**From:** [Guymer, Tim](#)  
**To:** [Aquind Interconnector](#)  
**Cc:** [Guymer, Tim](#); [Richard Turney](#); [McCart, Gemma](#); [Ackerman, Ian](#); [Drury, Holly](#); [Stickland, Caroline \(Solicitor\)](#); [Hirst, Chris](#); [Murray, Chris \(Planning\)](#); [Richard Turney](#); [Joel Semakula](#)  
**Subject:** EN020022 Aquind Interconnector - Deadline 5 submission from Hampshire County Council (Reference: 20025080)  
**Date:** 30 November 2020 17:03:51  
**Attachments:** [Aquind Deadline 5 HCC overview of oral submissions for Dec hearings\\_20025080.pdf](#)  
[Aquind Deadline 5 HCC submission\\_20025080.pdf](#)

# Hampshire County Council's Deadline 5 Submission

## Highway Authority Update

Plate 6 - Proposed ~~banksman locations~~ construction traffic management on Day Lane - will be replaced with full page image when issued as PDF

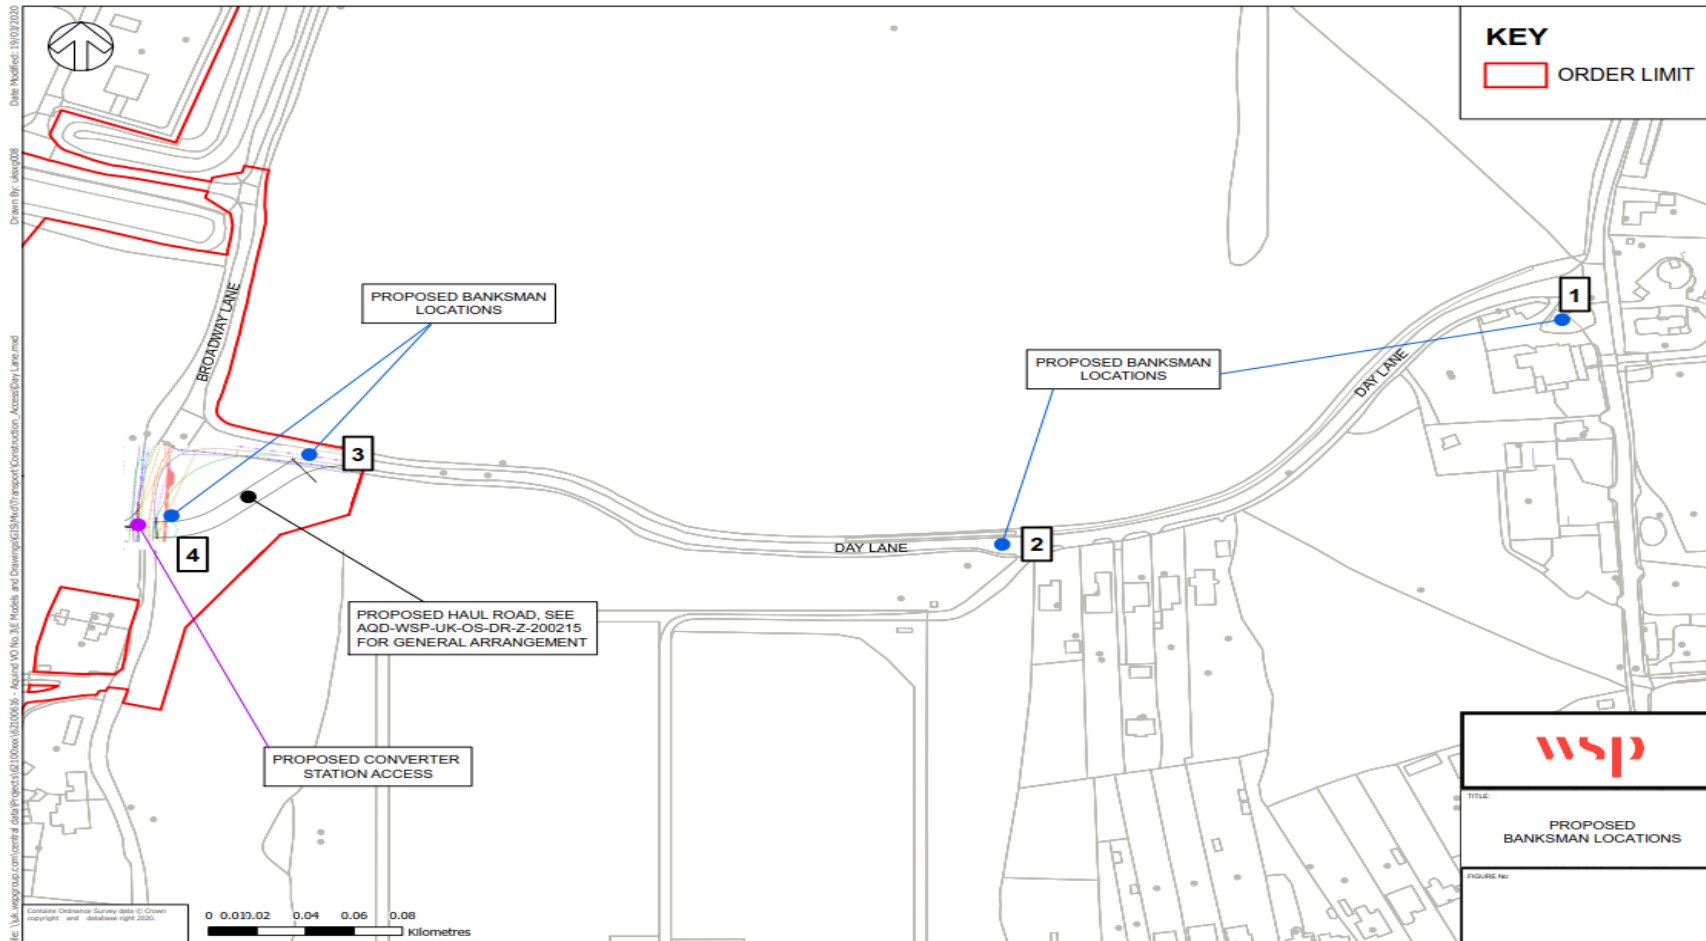
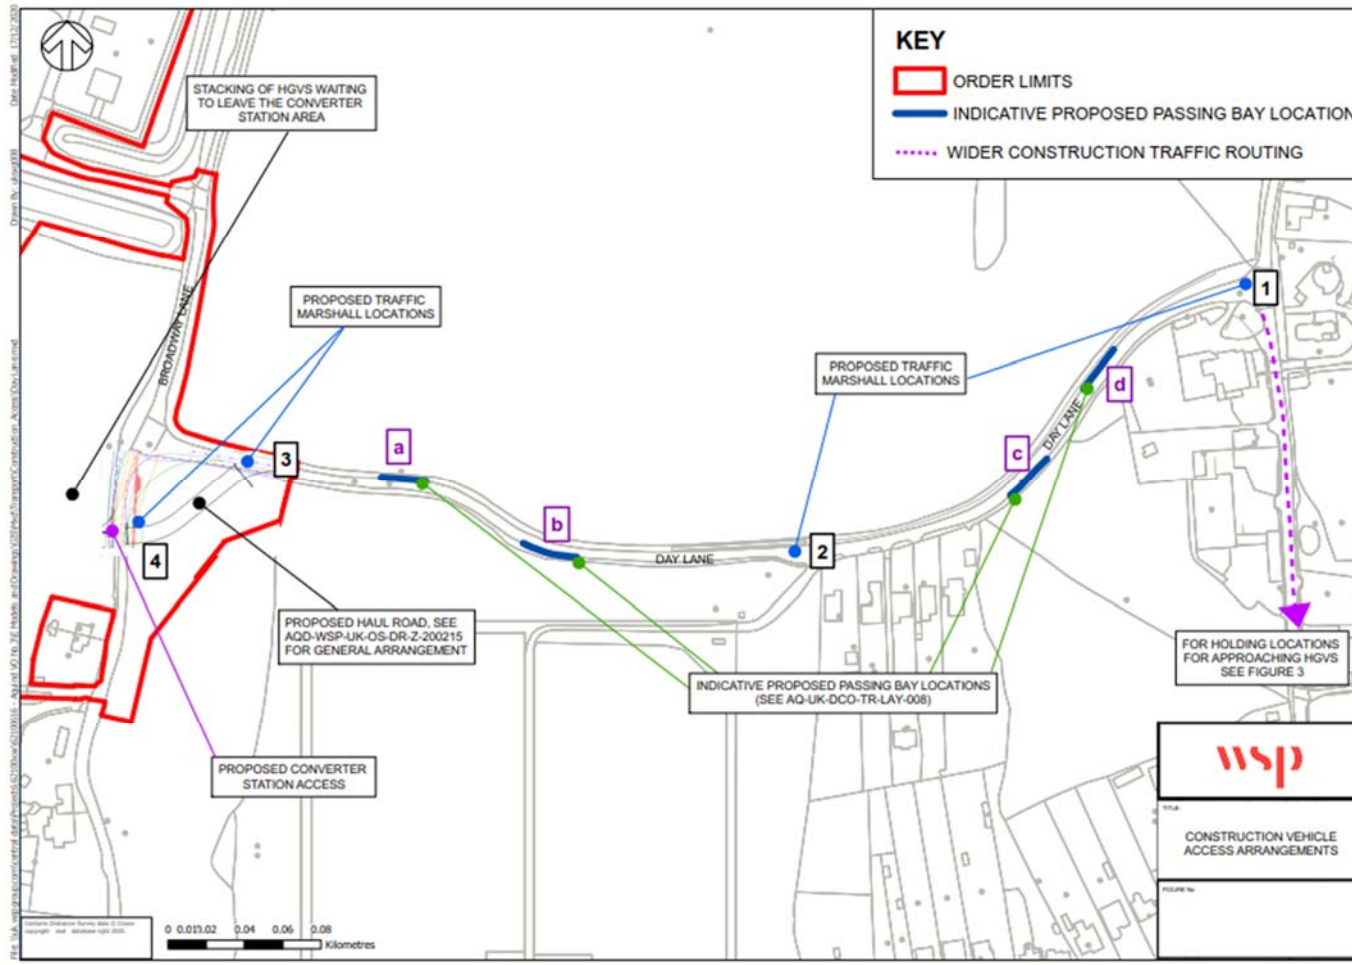
Following HCC's Deadline 3 response, further discussions have been held with the Applicant to understand how traffic movements will be managed along Day Lane. HCC's Deadline 3 response questioned the traffic management strategy for Day Lane. This was primarily focussed on the inability of a HGV and a car to pass on Day Lane and the lack of available passing spaces, the proposed use of Banksmen to control HGV movements and the safety issue of holding cars and goods vehicles at the junction with Day Lane/Lovdean Lane and the properties along Day Lane. It is understood that the Applicant is currently working on an updated traffic management strategy along Day Lane. HCC would welcome sight of the updated strategy when available. The Applicant has been referred to the approved Construction Traffic Management Plan (CTMP) for managing lorry movements at the IFA2 Chilling site<sup>1</sup> where access along Hook Lane, Fareham is of a similar nature with regards to the constraints of a rural road network.

It has been noted that Chapter 22 of the Environmental Statement (ES) states that there will be 86 lorry movements operating in 8 hour shifts along Day Lane. The CTMP proposals for Day Lane refer to 6 lorry movements an hour. Clarity is therefore sought on this point as the numbers do not appear to be consistent.
